WOODMOOR

Water & Sanitation District No. 1

April 8, 2020

RE: North Bay – Construction Plan Set

Shore-ditch heights - water

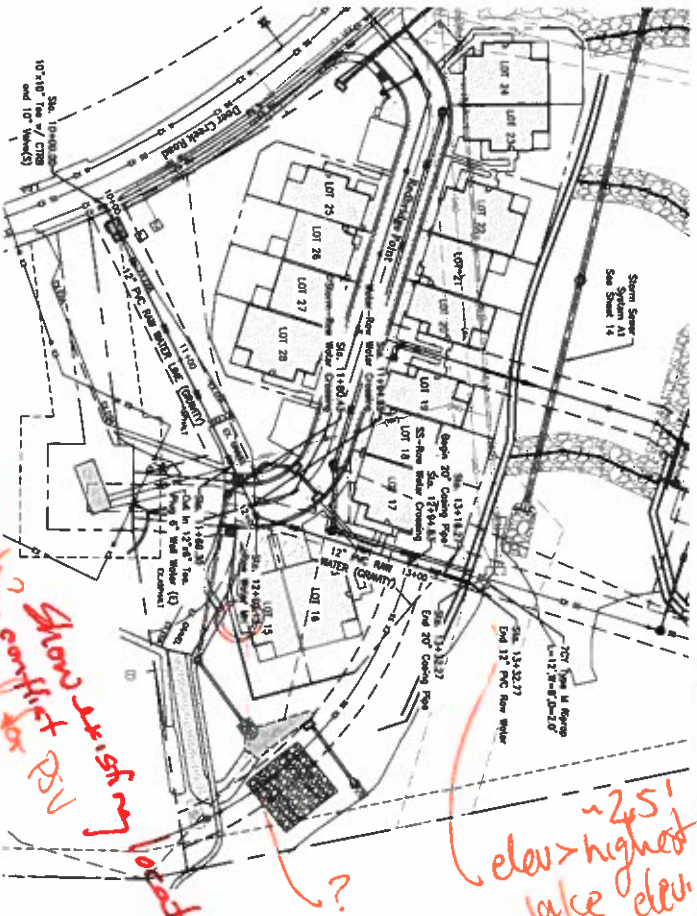
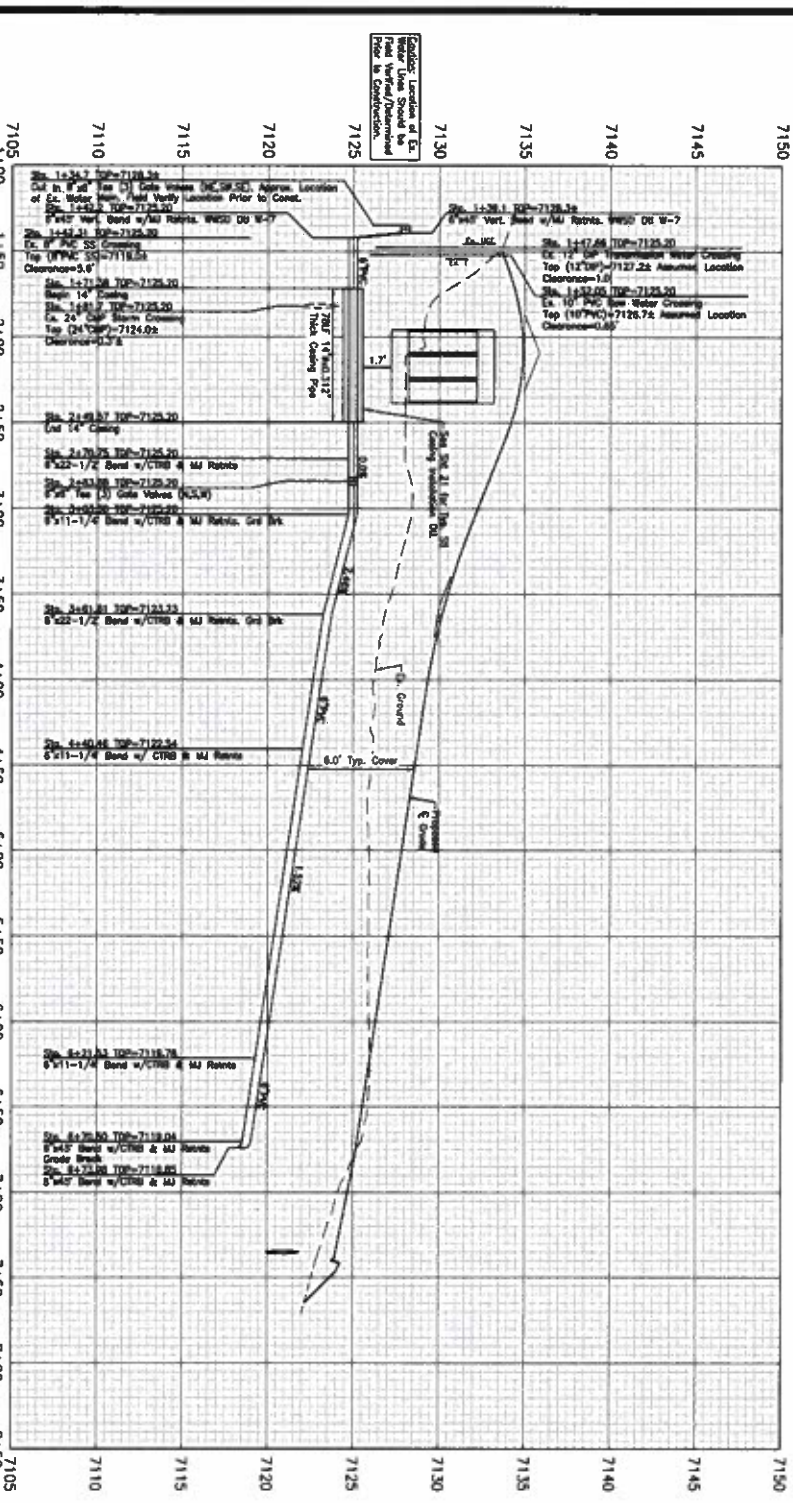
1. The last PSV vault that was proposed to be moved for a subdivision project was too heavy for the contractor to move. It had a pour-in-place vault. The project manager decided to install a new vault instead. That said, do you want to include the District's PRV/PSV Vault Detail in case this happens again? Otherwise, include a note stating that if the existing assembly cannot be reused, coordinate with the District for specifications on a new assembly.

North Bay at Lake Woodmoor
Shoreditch Heights -- 6" Watermain Plan and Profile
12" Water Storage Pipeline Plan and Profile
El Paso County, Colorado

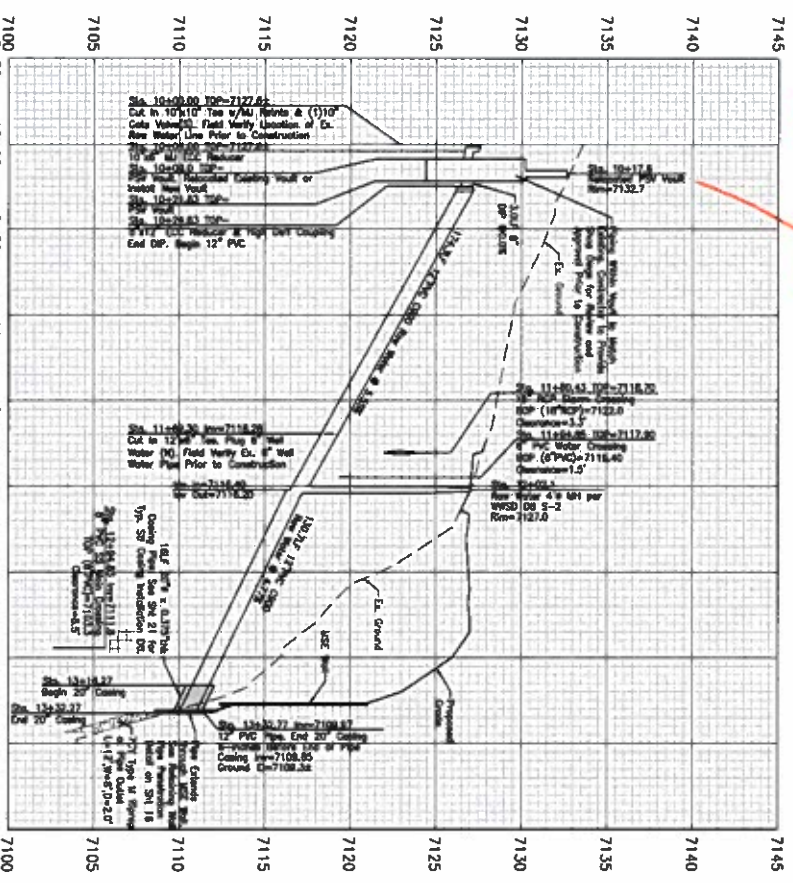
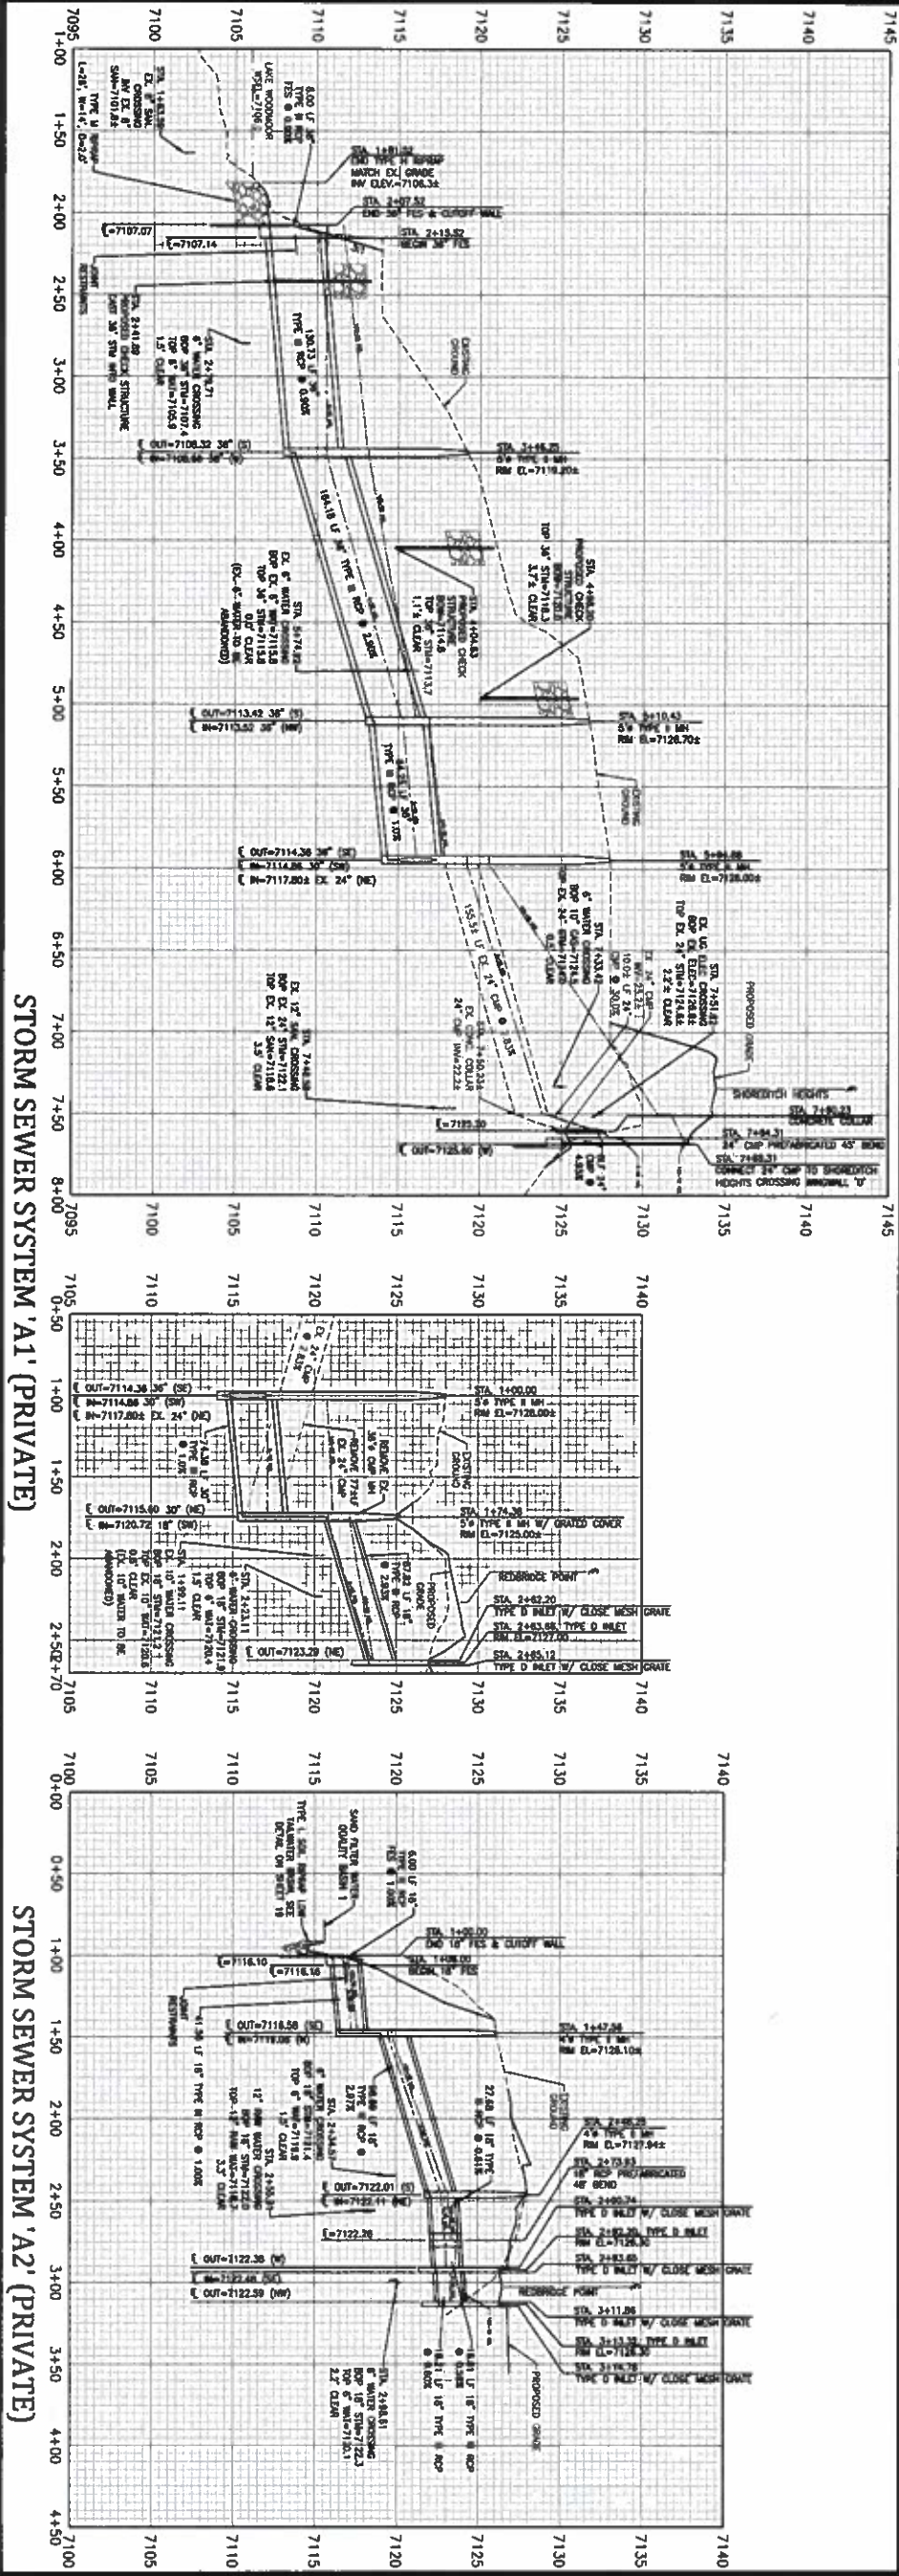
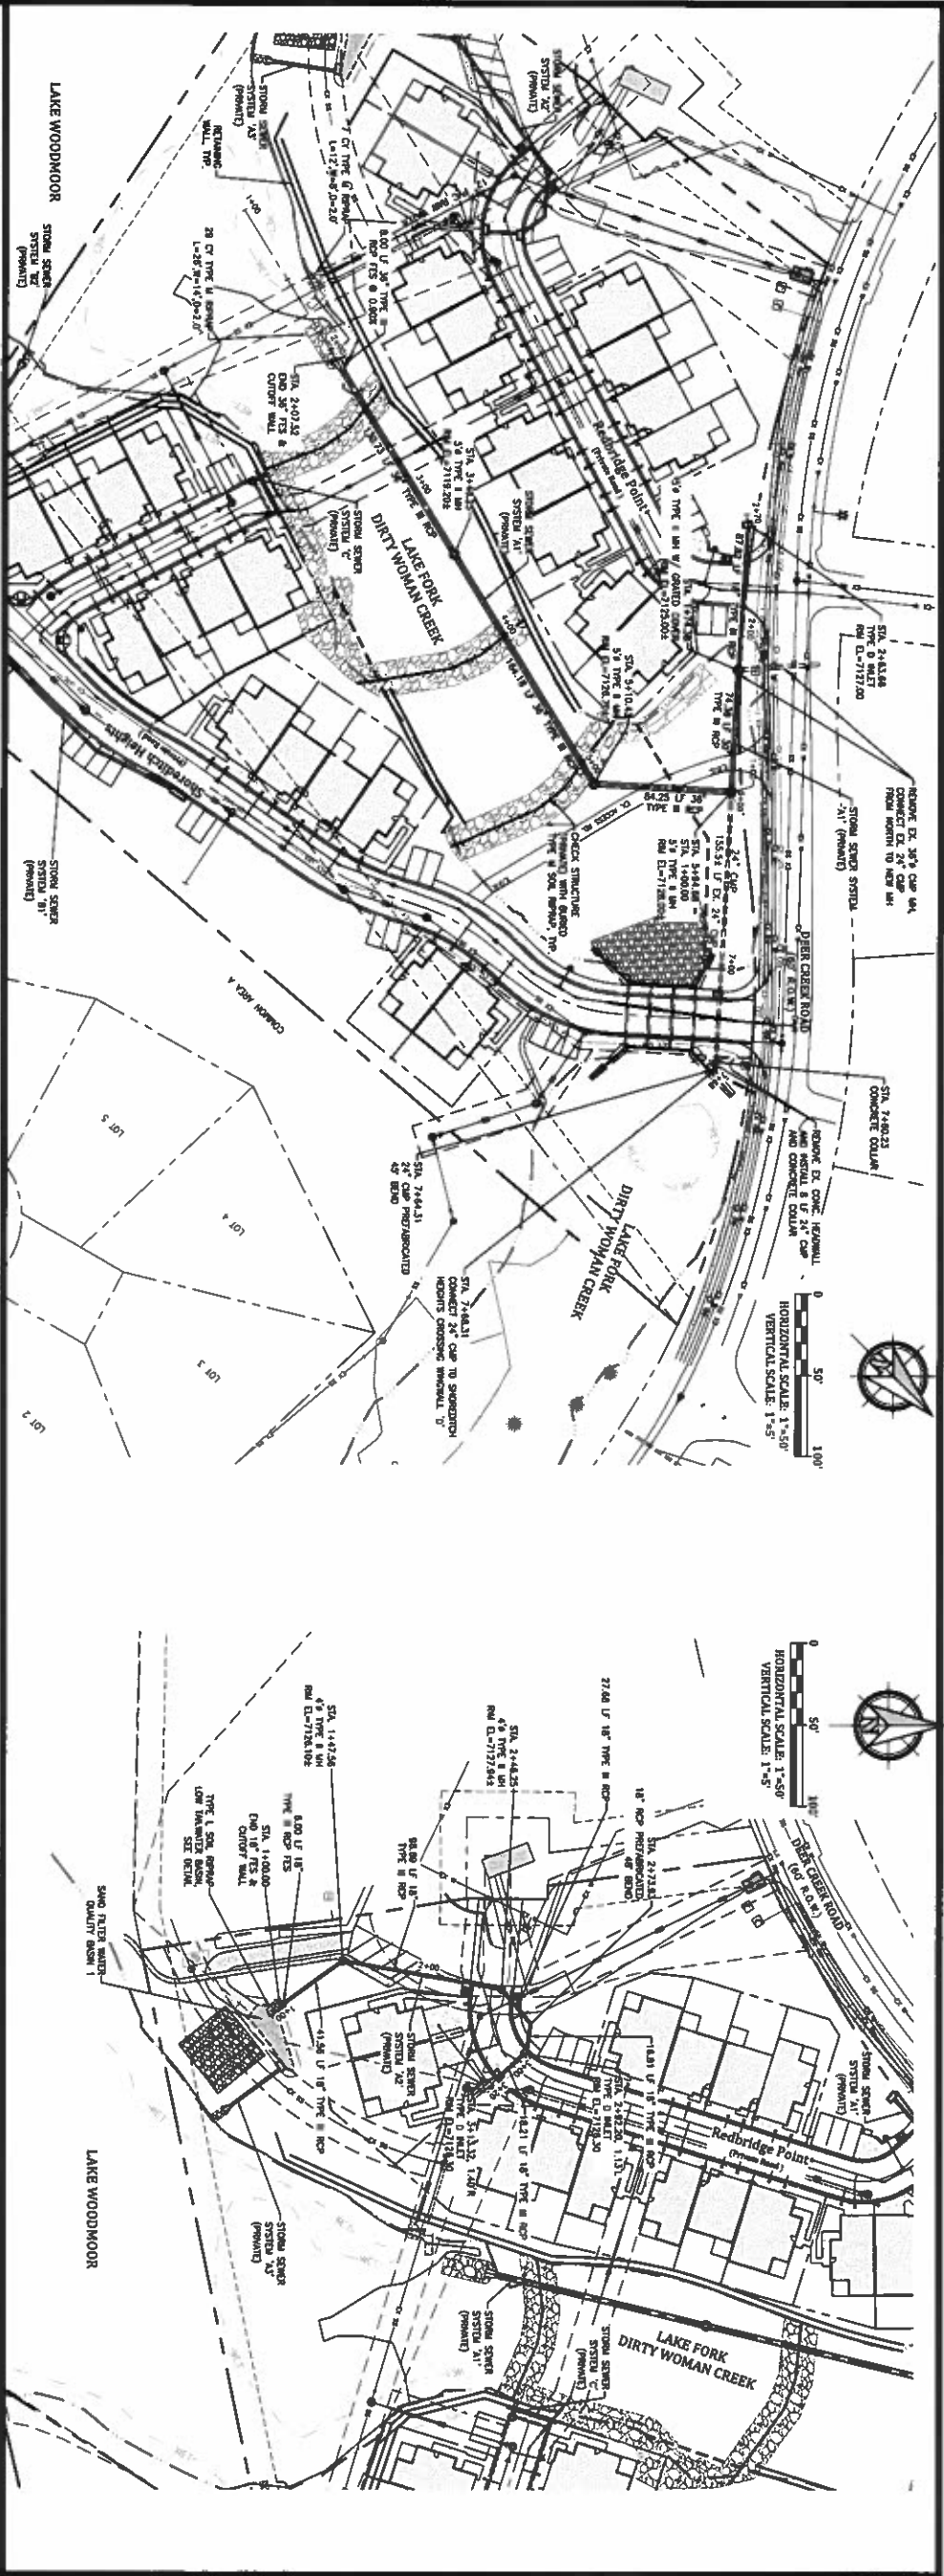
2. Please show more detail on pumped water storage pipeline demolition, repair, and new alignment.
 - a. Show the existing facilities to be demolished with hatching.

- b. On new work plan, show in bold the areas to be repaired after existing facilities removed. Add note stating repair work must be performed under Woodmoor Water & Sanitation District System Specifications.

- c. Please show more detail on the pumped water storage pipeline terminal at Lake Woodmoor. It appears that the flow will make an apx. 90-degree bend to enter the lake. Detail must include erosion control measures taken, which should account for head cut and effects of flow on the bend.
